CHARLOTTE - MECKLENBURG
PLANNING COMMISSION

INTER - OFFICE COMMUNICATION

SUBJECT: Administrative approval for Petition No. 2006-04 by Terri and Stephan McGirt.

SCHEMATIC SITE PLAN
 SHEET SSP 1
 ORIGINAL SUBMITTAL 07/05
 REVISION 07/06
 REVISION 07/06
 REVISION 07/06
 REVISION 07/07

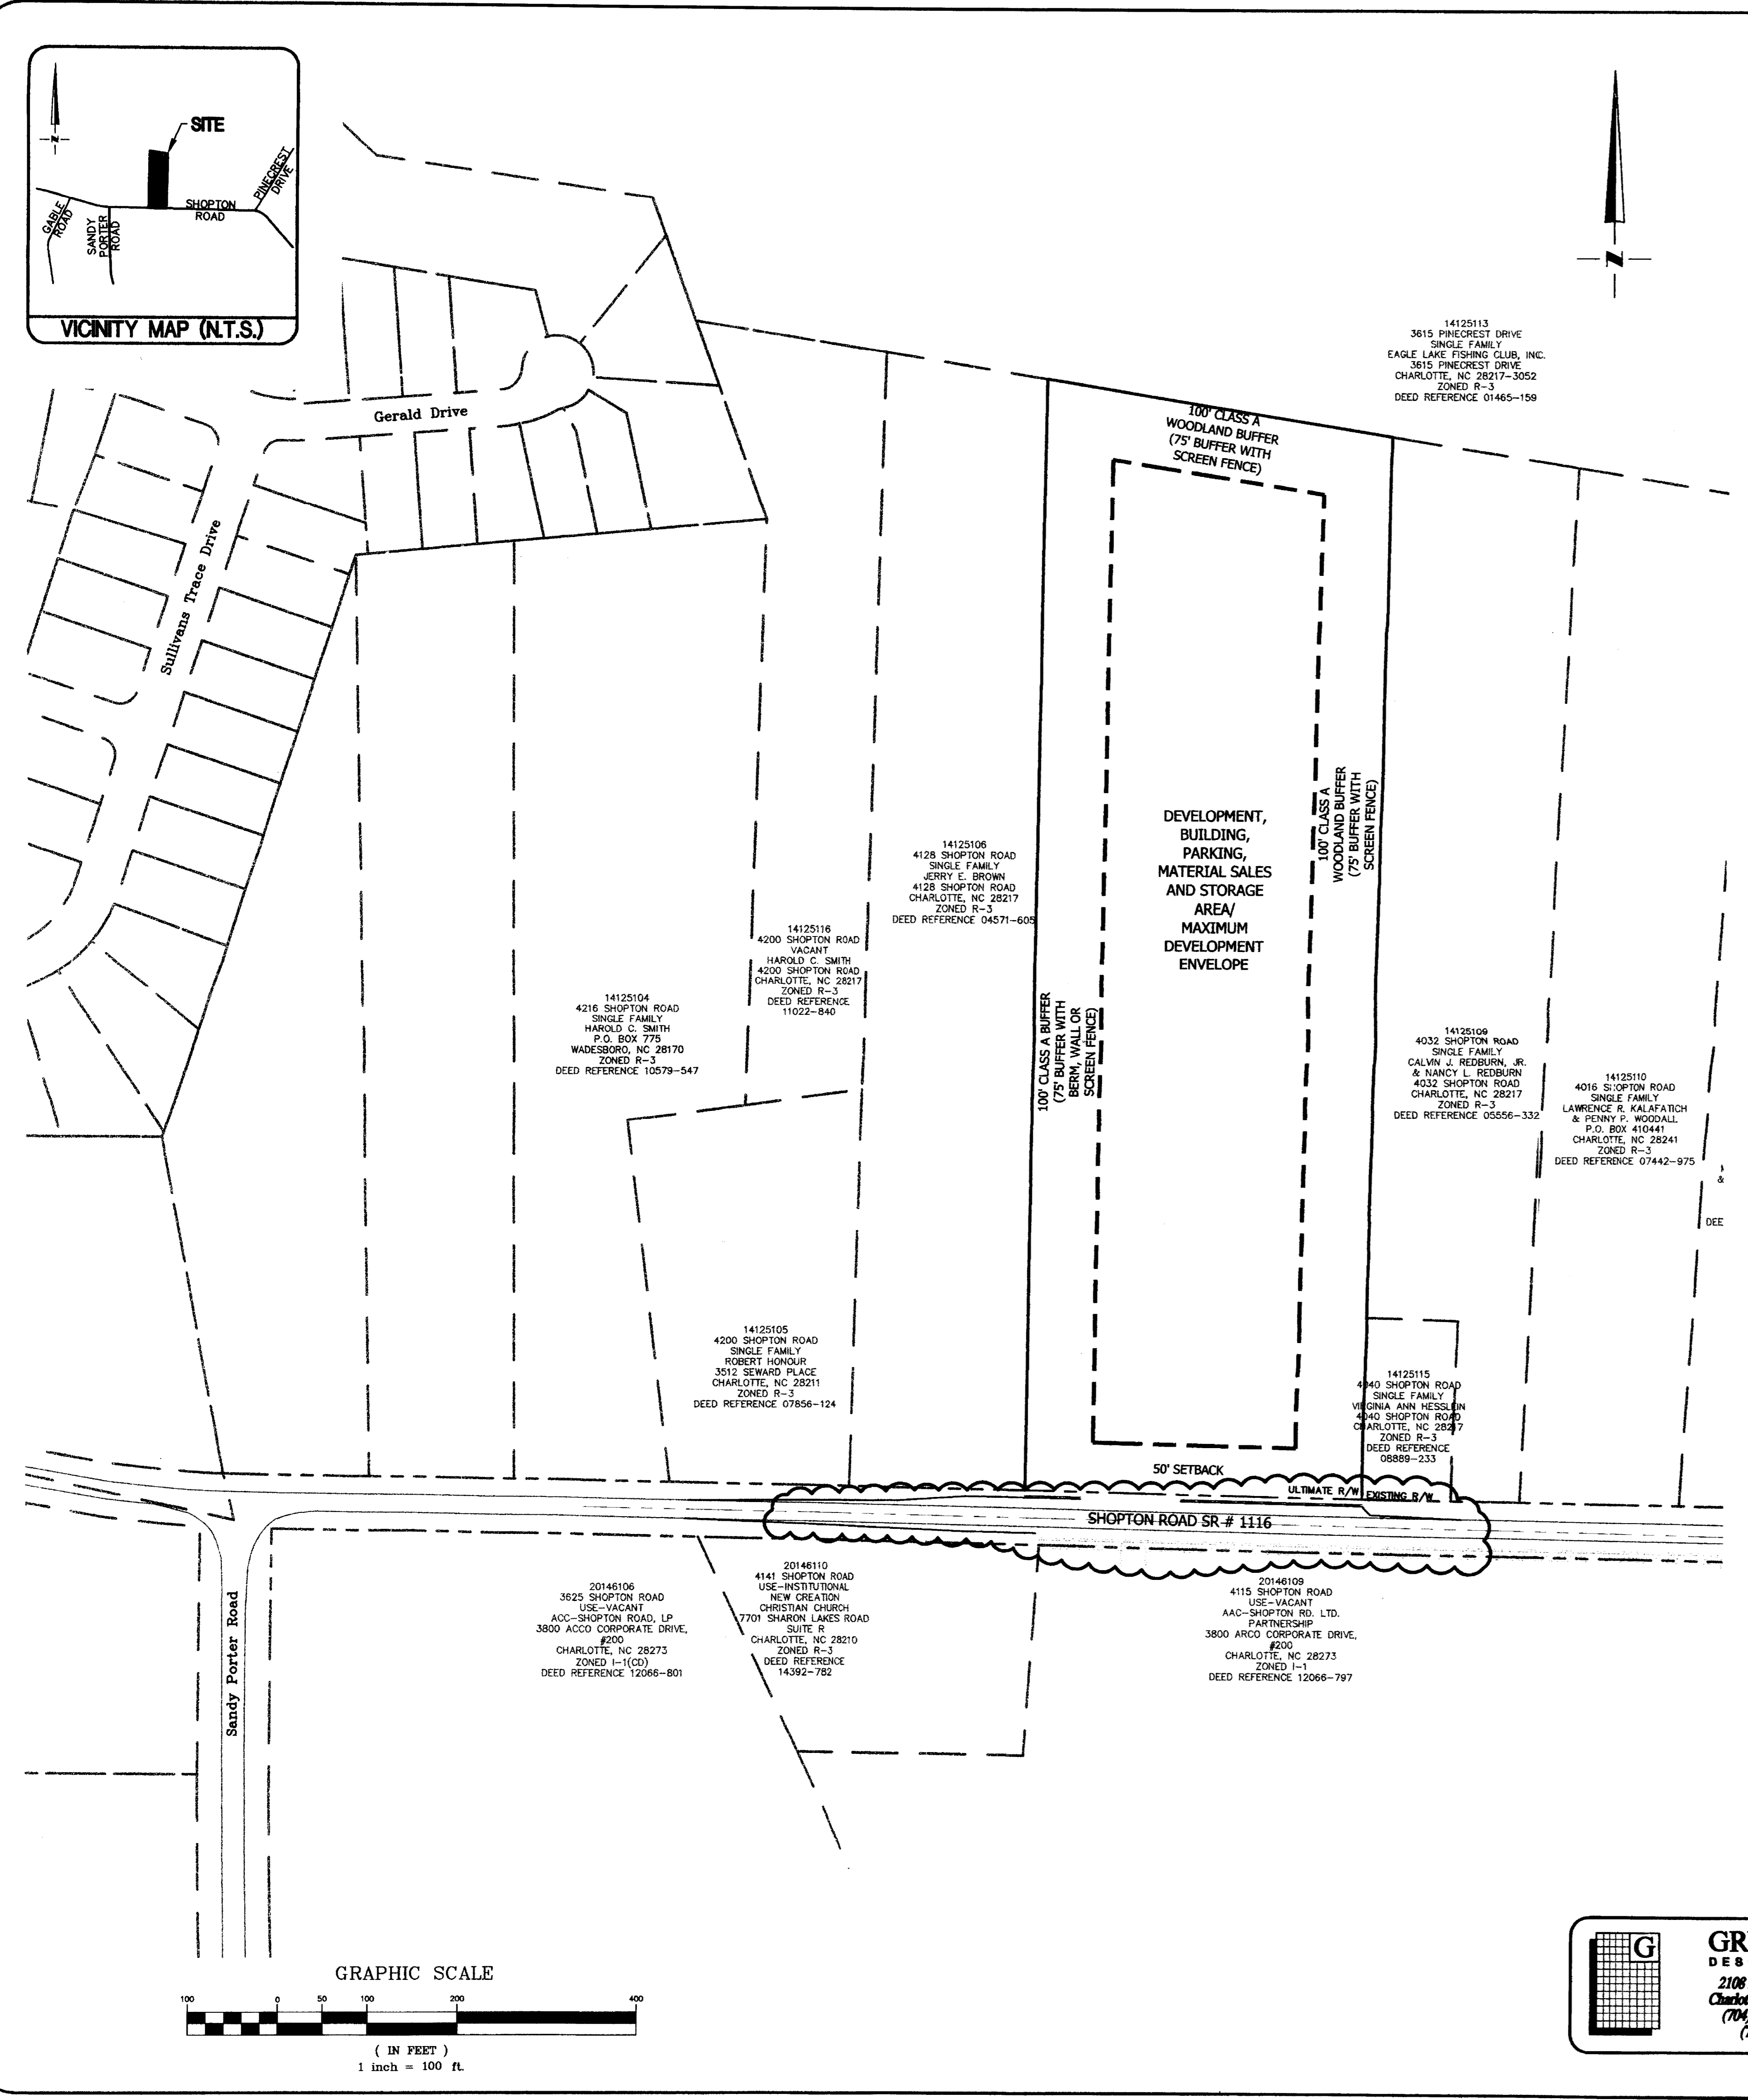
Attached are revised plans for the above petition. The plans have been revised to show a minor change to the site layout. The warehouse will now be part of the office building. Since this is a minor change, I am administratively approving these revised plans. Please use these attached plans when evaluating requests for building permits and certificates of occupancy.
